26 May 2020

ARTC REF: 3-0000-260-EAP-00-LT-0007

**Inland Rail – Narrabri to North Star Project (SSI-7474)**  
**Response to submissions on the SPIR**  
**Major Project Portal task EXH-2646**

Figure 6.1 Concept design for Moree Station works – site general arrangement

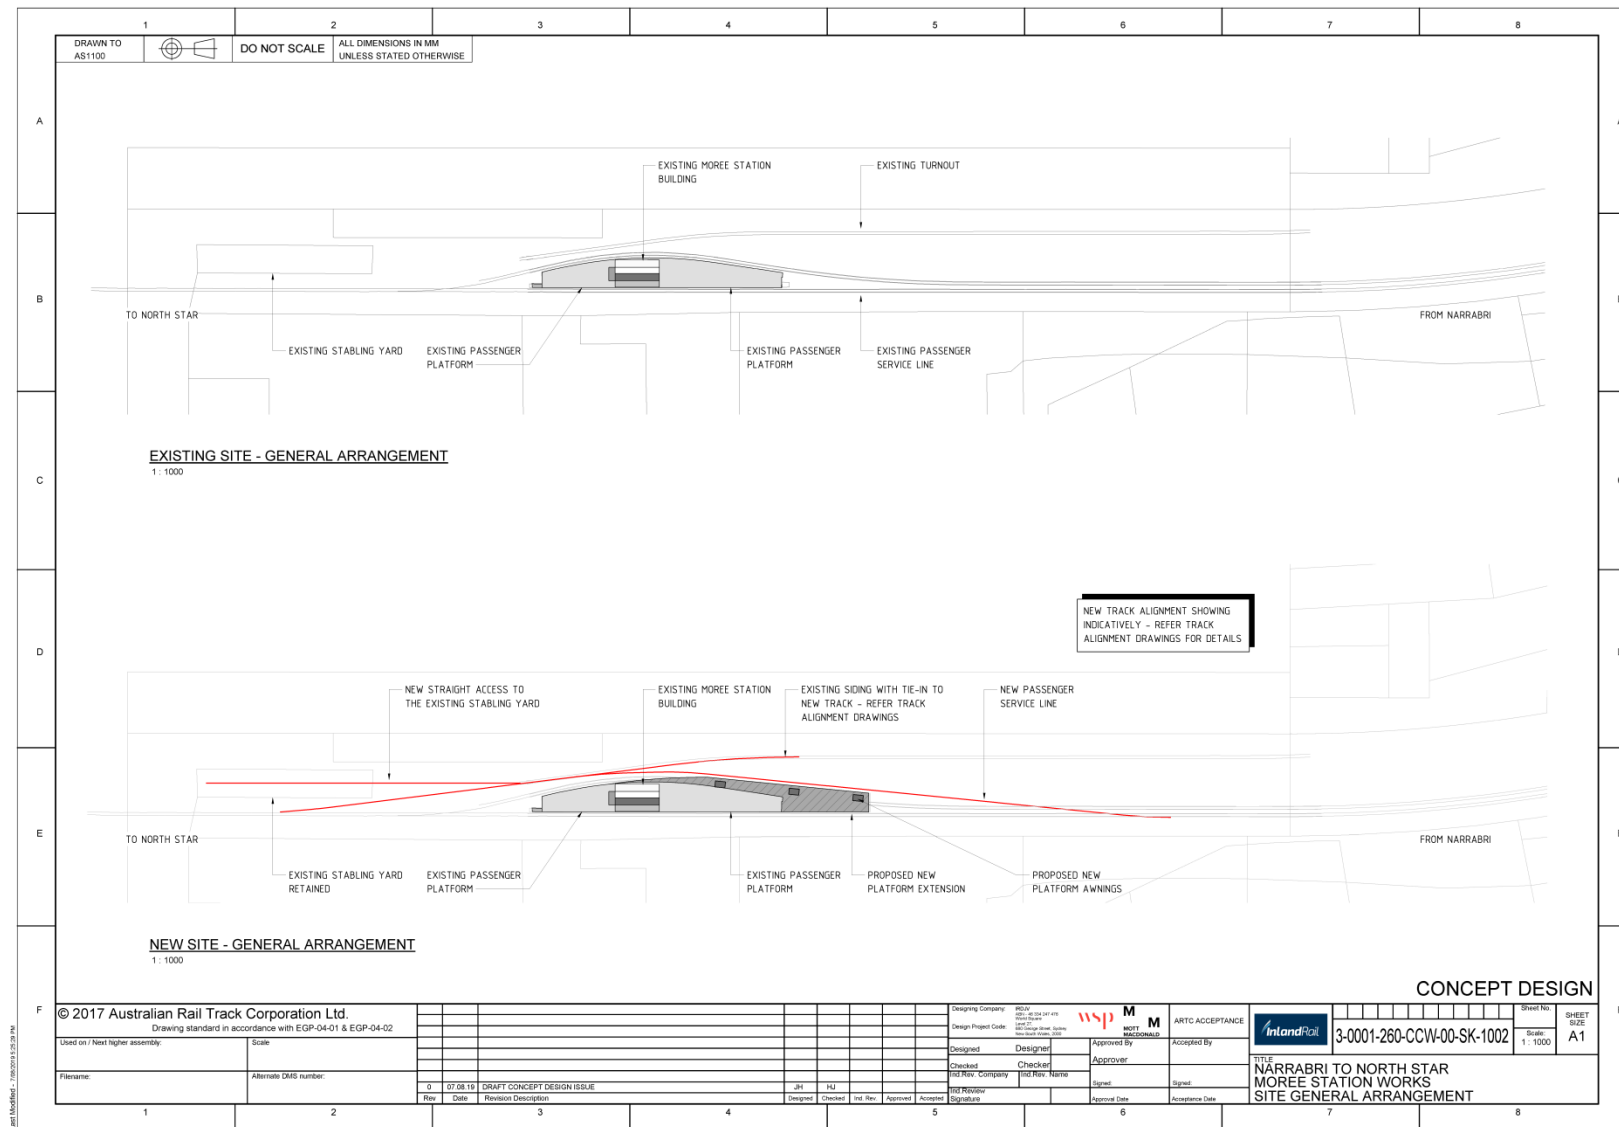
Heritage NSW, on behalf of the Heritage Council, have previously raised concerns of the proposed demolition of Gwydir River and Mehi River bridges as part of the Inland Rail Project. It is understood that ARTC has refined the design with the aim of addressing the several issues raised in submissions, while also minimising potential impacts. Therefore, Narrabri to North Star has been divided into two phases, the first of which is the preferred infrastructure (the subject of this referral). The Gwydir River and Mehi River bridges are no longer within the preferred infrastructure site but will part of the Stage 2 of Narrabri to North Star project.

Heritage NSW would like to be consulted on Stage 2 (sic), specifically regarding the treatment of Gwydir River and Mehi River bridges. We would be happy to meet with you to assist progression this project.

Heritage NSW's comments in respect of non-Aboriginal Heritage are noted.

Consultation with Heritage NSW will be progressed as part of the Phase 2 project.
